From: Sue Howell <Sue.Howell@arun.gov.uk>
Sent: 10 May 2021 17:39
To: Planning.Responses <Planning.Responses@arun.gov.uk>
Cc: Raymond Cole <Raymond.Cole@arun.gov.uk>
Subject: RE: Planning Consultation on: BN/18/21/RES

Application ref: BN/18/21/RES

Description: 5000 sq m of light industrial floor space (ClassB1 (b)/(c) following grant of outline planning permission WA/22/15/OUT (resubmission following BN/57/19/RES). This site is in CIL Zone 1 (Zero Rated) as other development.

Summary recommendation : Recommend approval of hard and soft landscape details contained within this BN/18/21/RES following grant of outline planning permission WA/22/15/OUT (resubmission following BN/57/19/RE

Planting Area No. 8

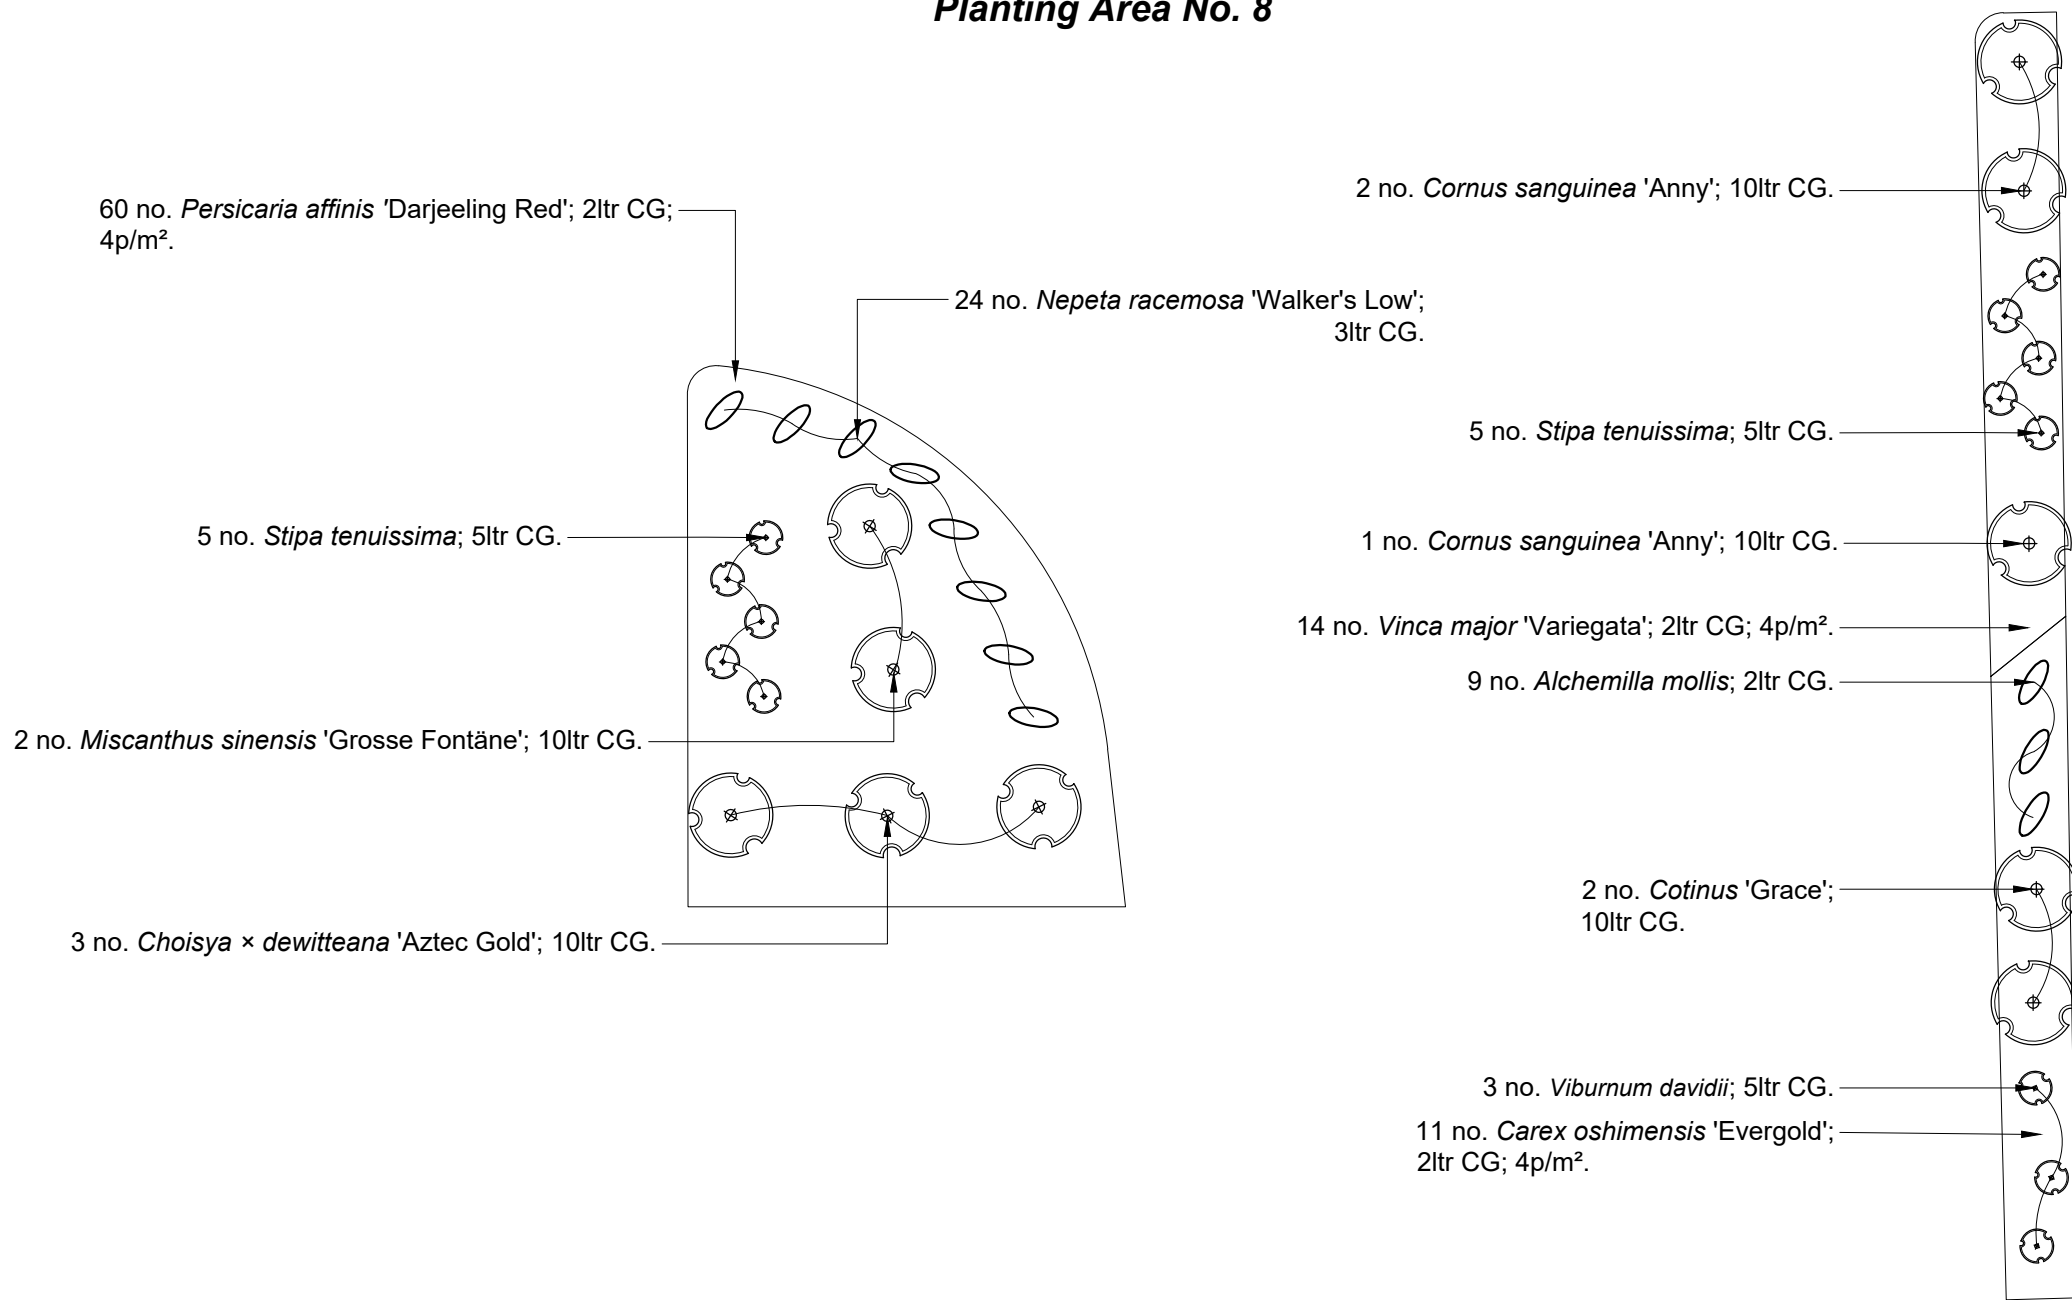
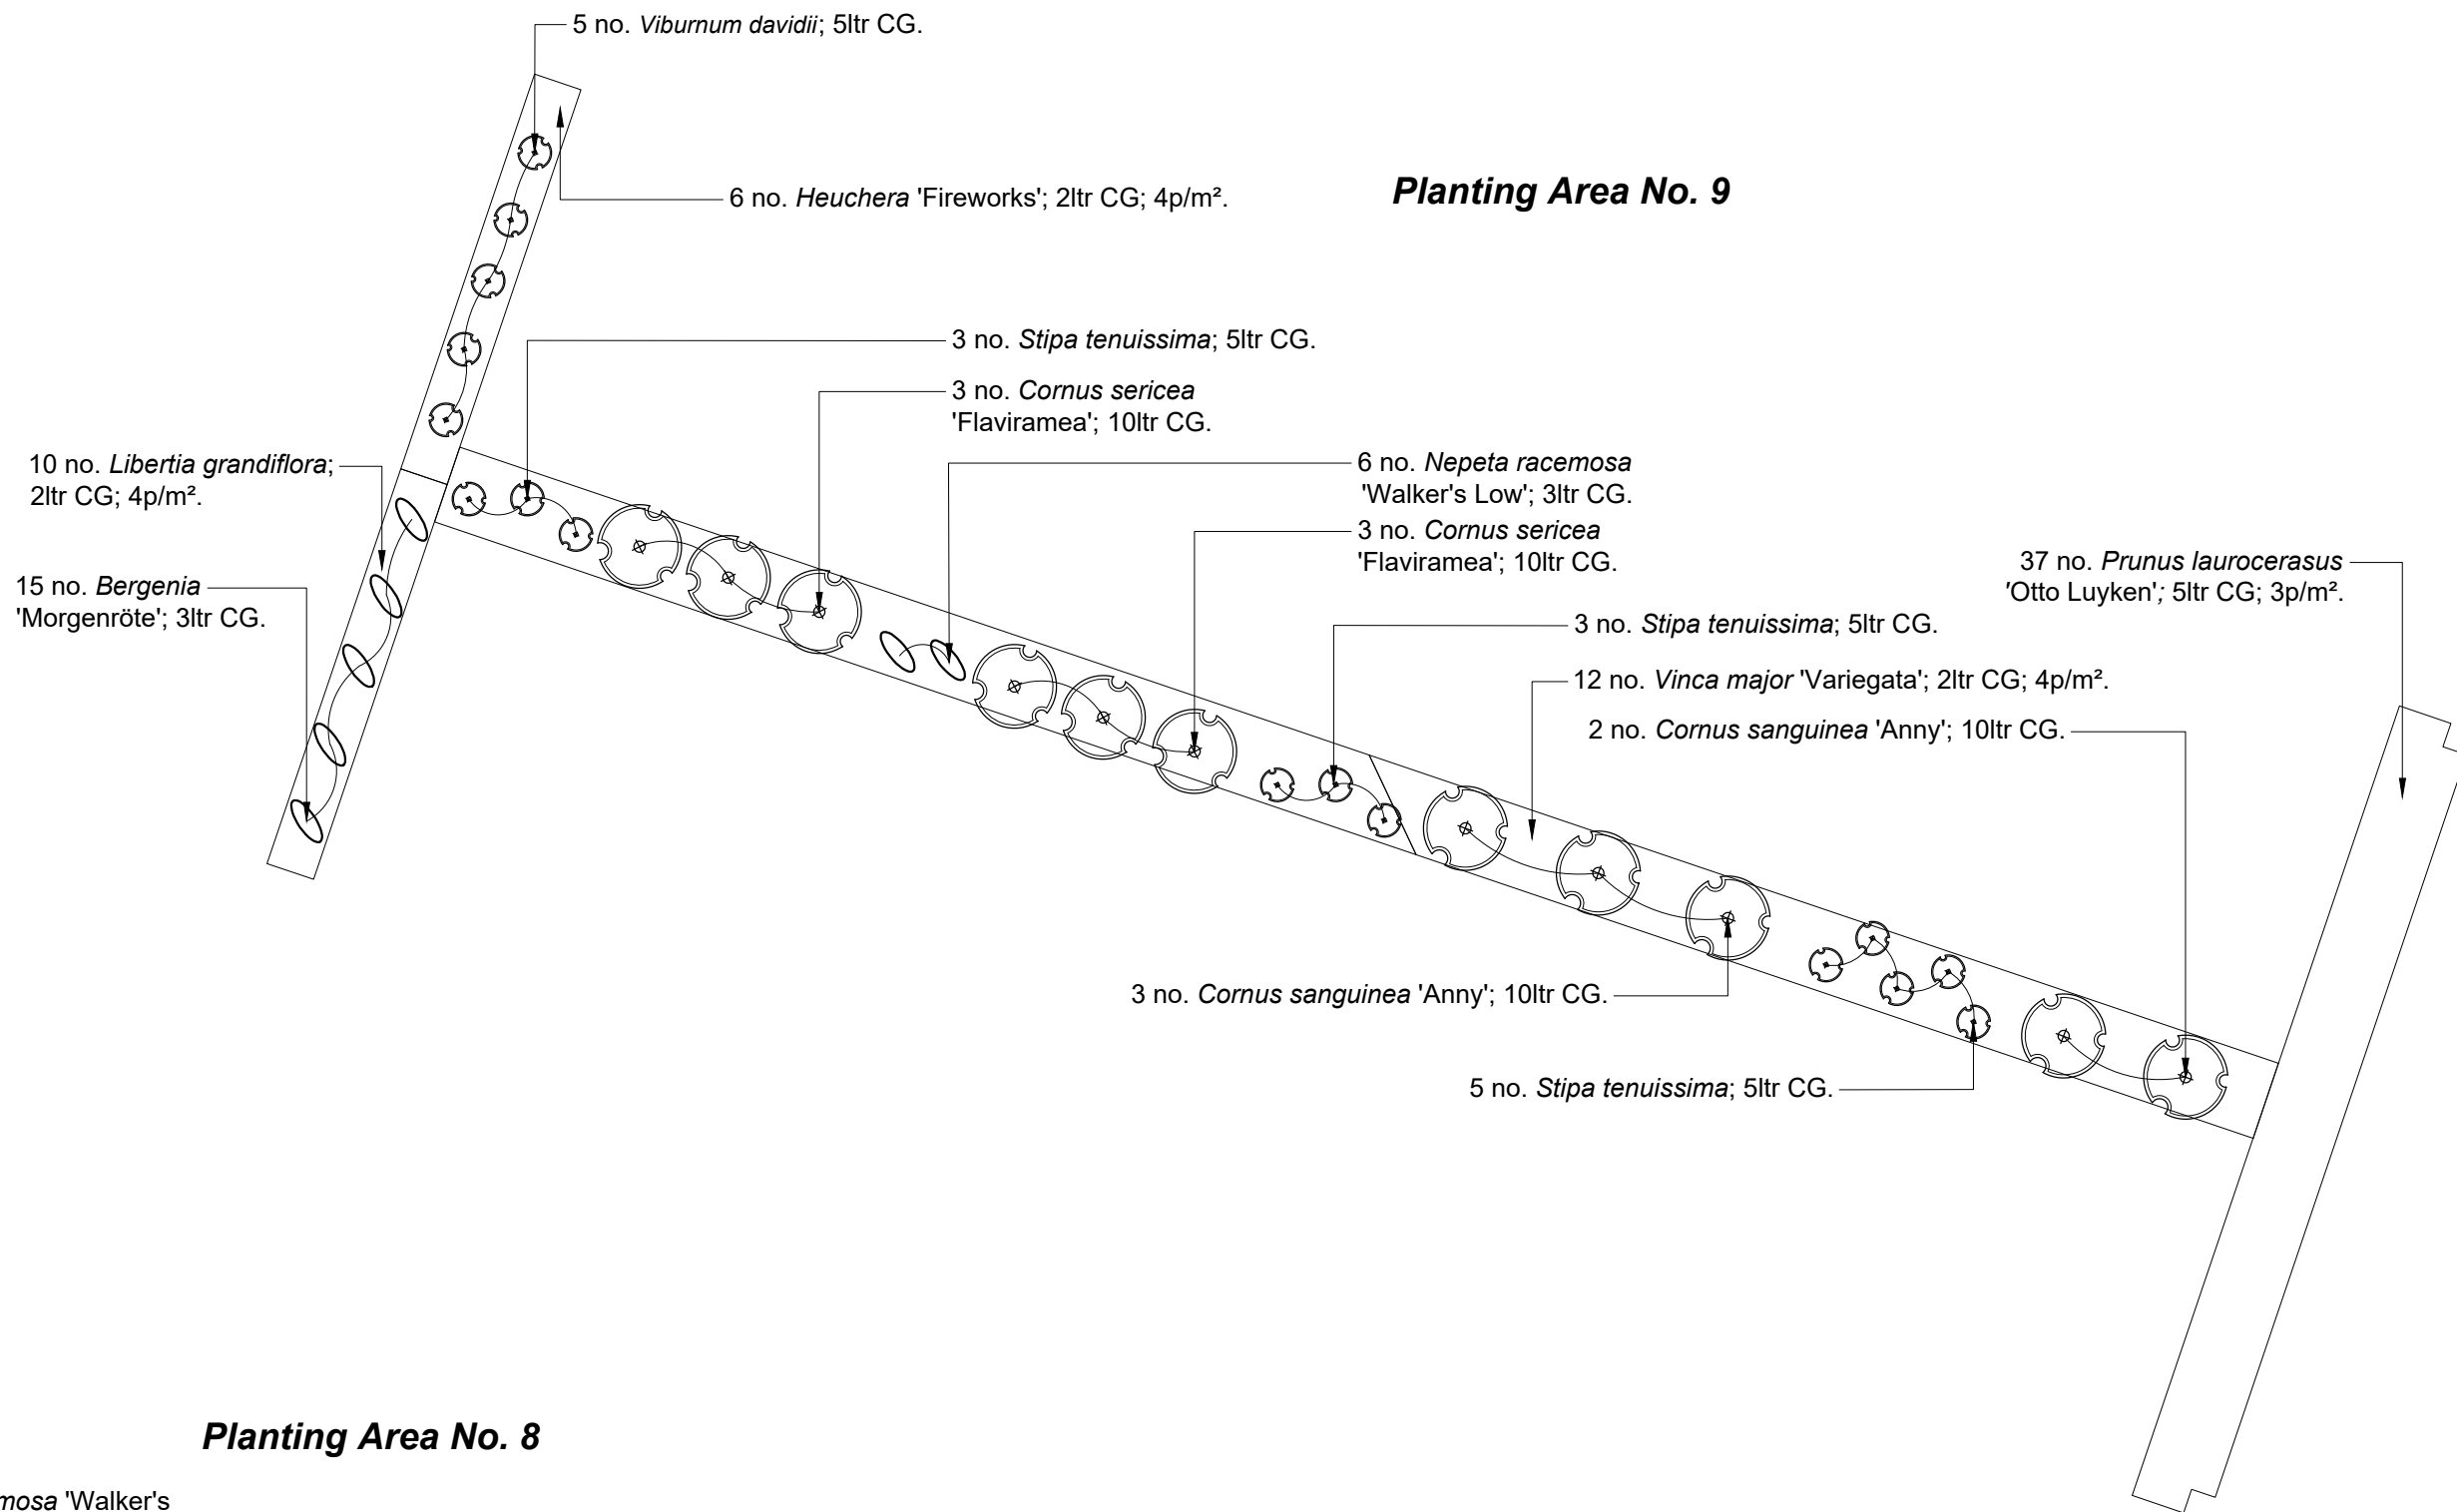
The information contained in Soft and Hard Landscape GA LLD-1773-LAN-DWG-100-REV10, Detailed planting plan ornamental planting LLD-1773-LAN-DWG-201-REV05, Detailed planting plan infrastructure planting LLD-1773-LAN-DWG-200-REV07, Detailed planting plan ornamental planting LLD-1773-LAN-DWG-202-REV04 proposes a well thought out and comprehensive scheme with trees, hedges, native planting, shrubs, grasses and buffer edge. The proposed scheme contains a good mix which will provide softening/screening improving the setting, increasingly over time as the planting matures. The scheme is adequately detailed with quantities and size at time of planting, providing trees which will add instant impact a species mix across the proposals both deciduous and evergreen which will add good biodiversity benefit to the site.
